Subject: AW/159/21/HH - Objection to Planning Application

I am writing to comment upon the planning application AW/159/21/HH which relates to the property neighbouring my own.

Drawing Title
Existing Plans & Elevations

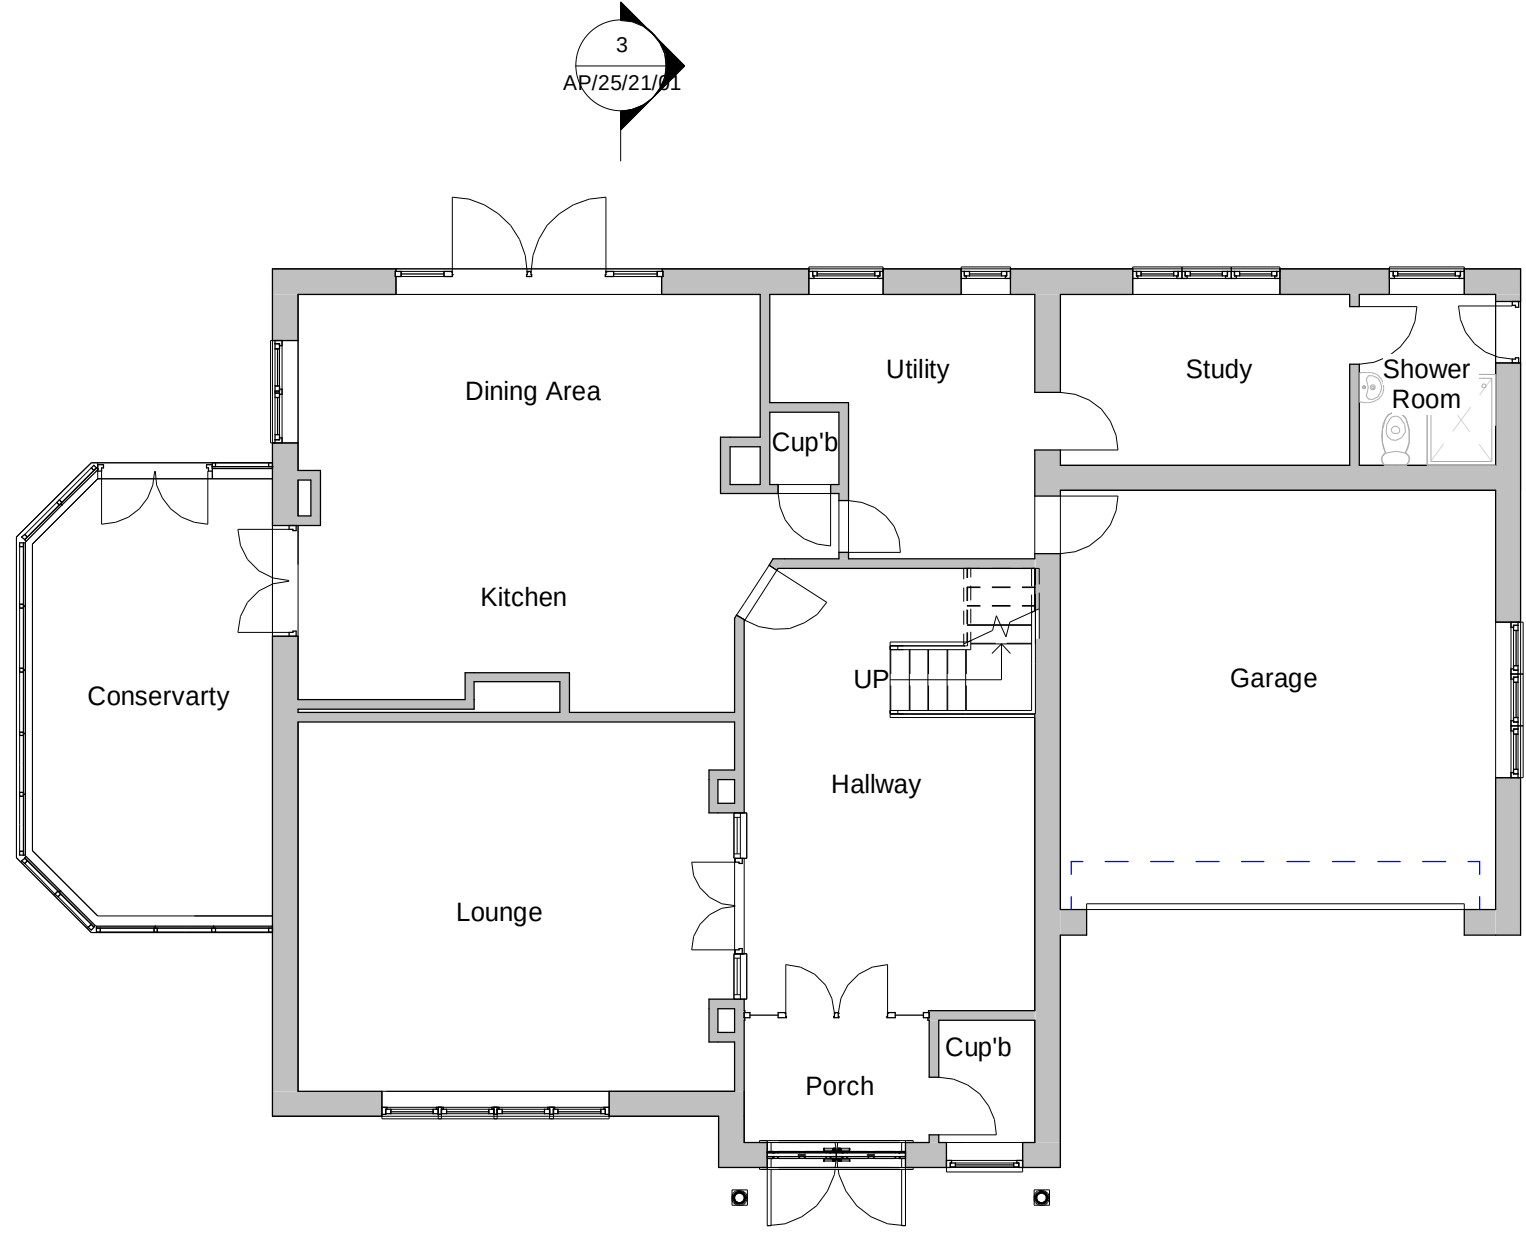
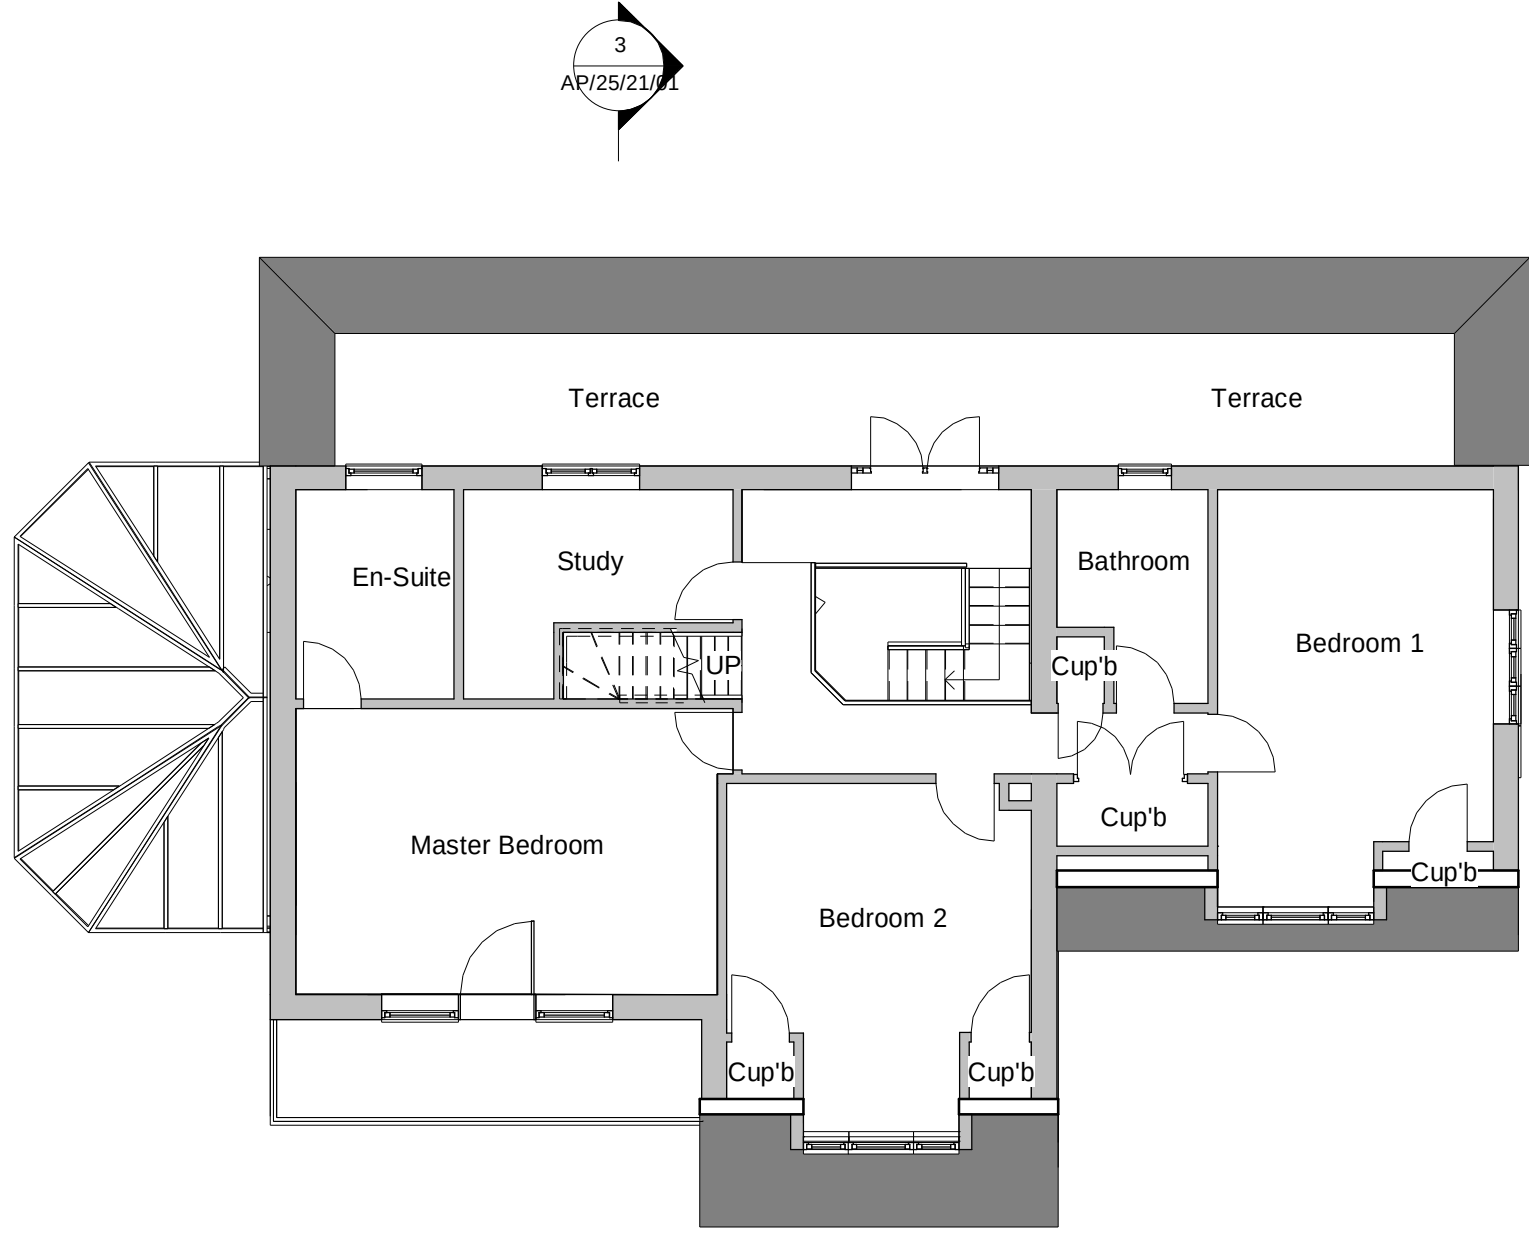
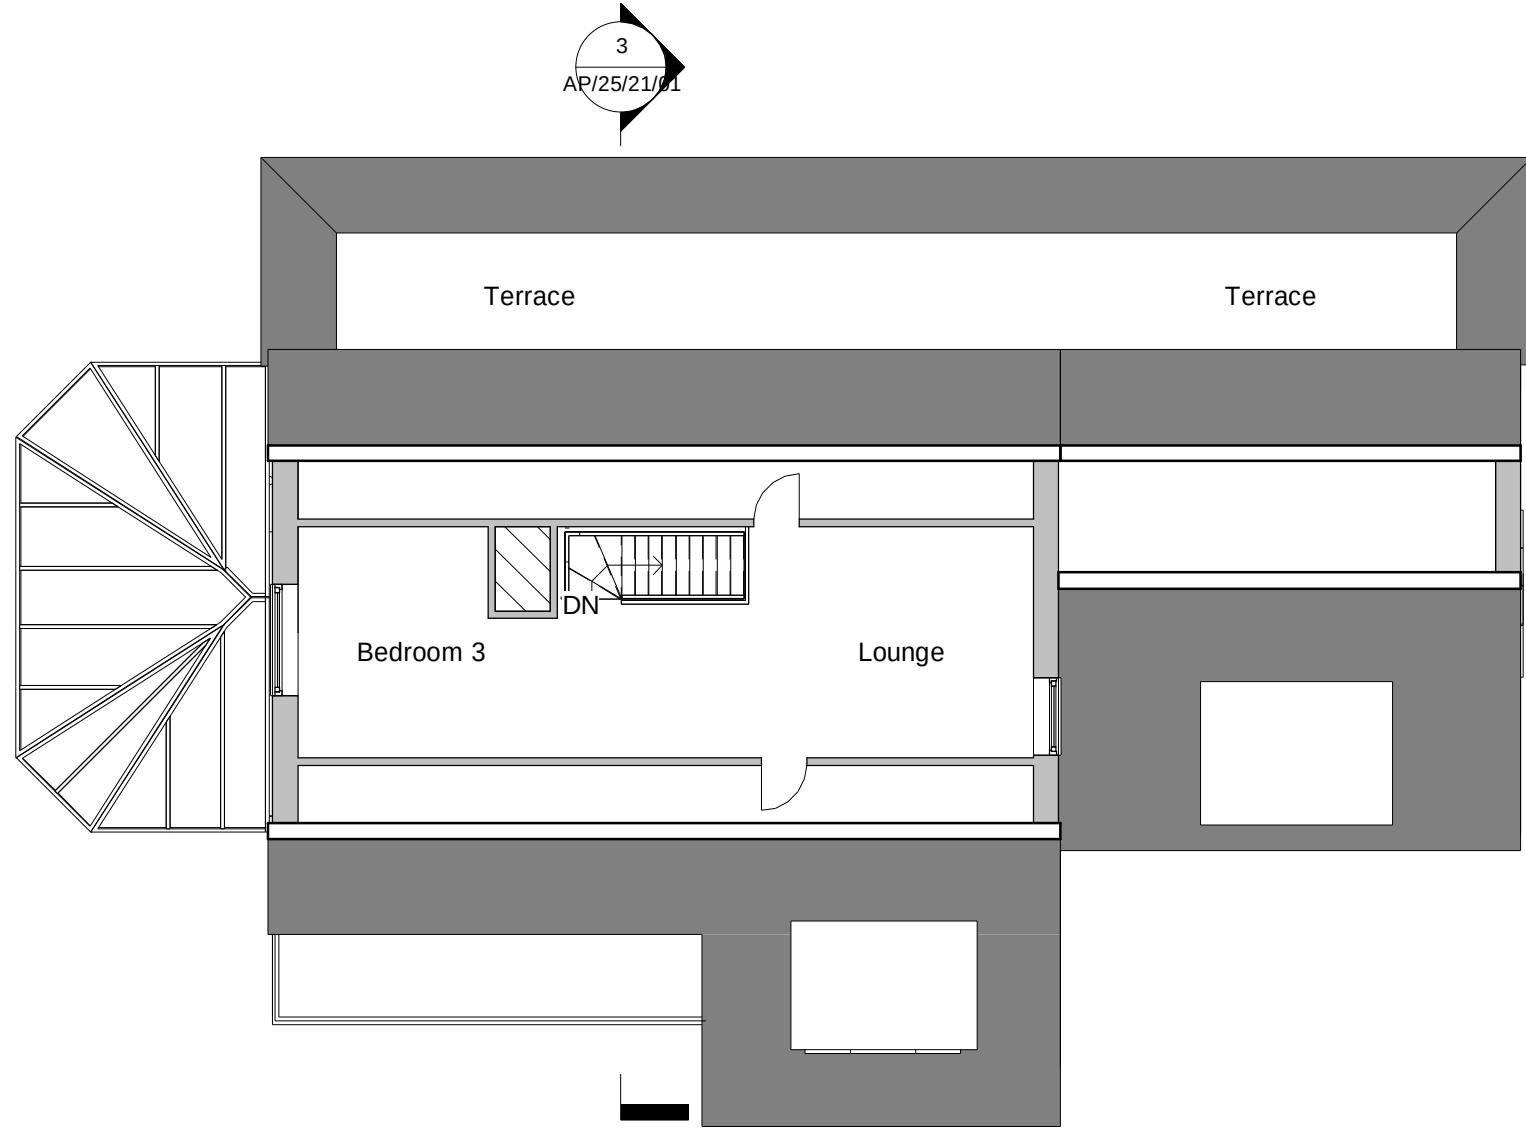
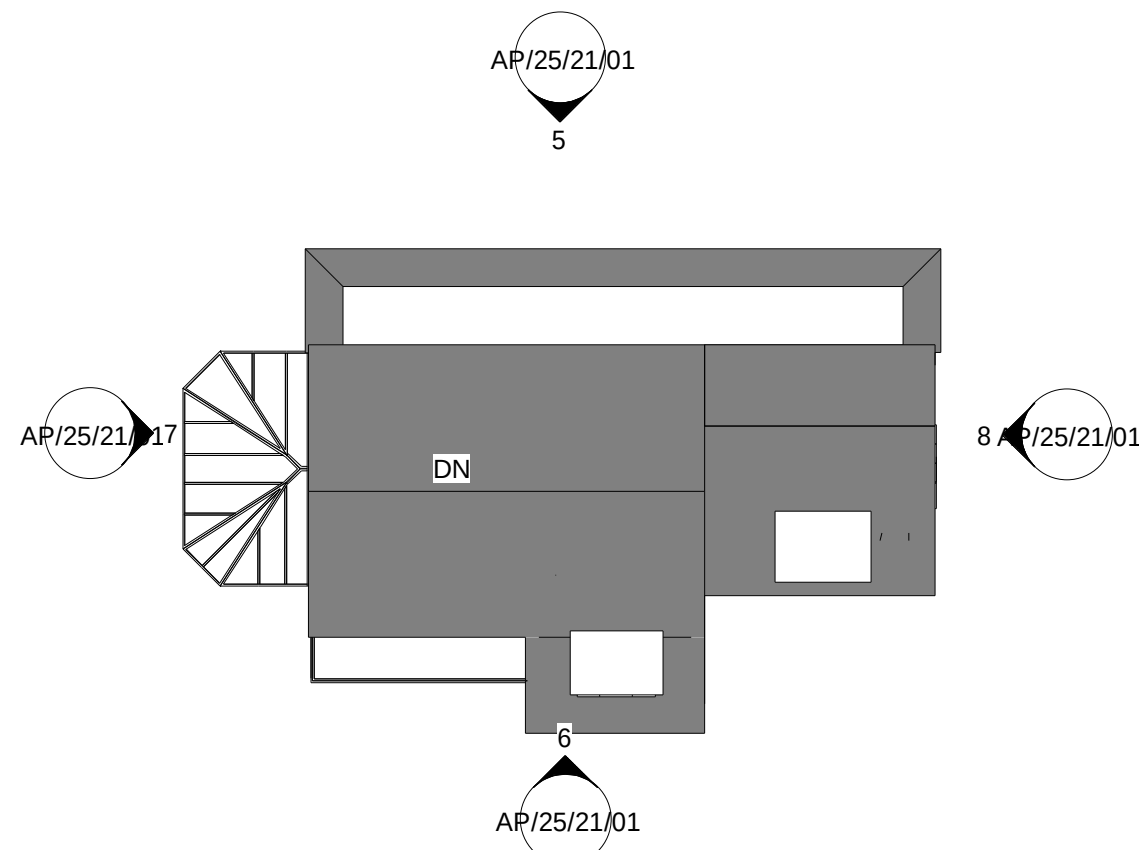
Before commenting on the proposals themselves, it is relevant to draw attention to the fact that the submitted drawings showing the "as existing" plans appear to be inaccurate. Objections already posted deal with some discrepancies between what is constructed and what was approved under AW/331/20/HH, and there appears to be additional discrepancy in the roof profile at the north east corner.
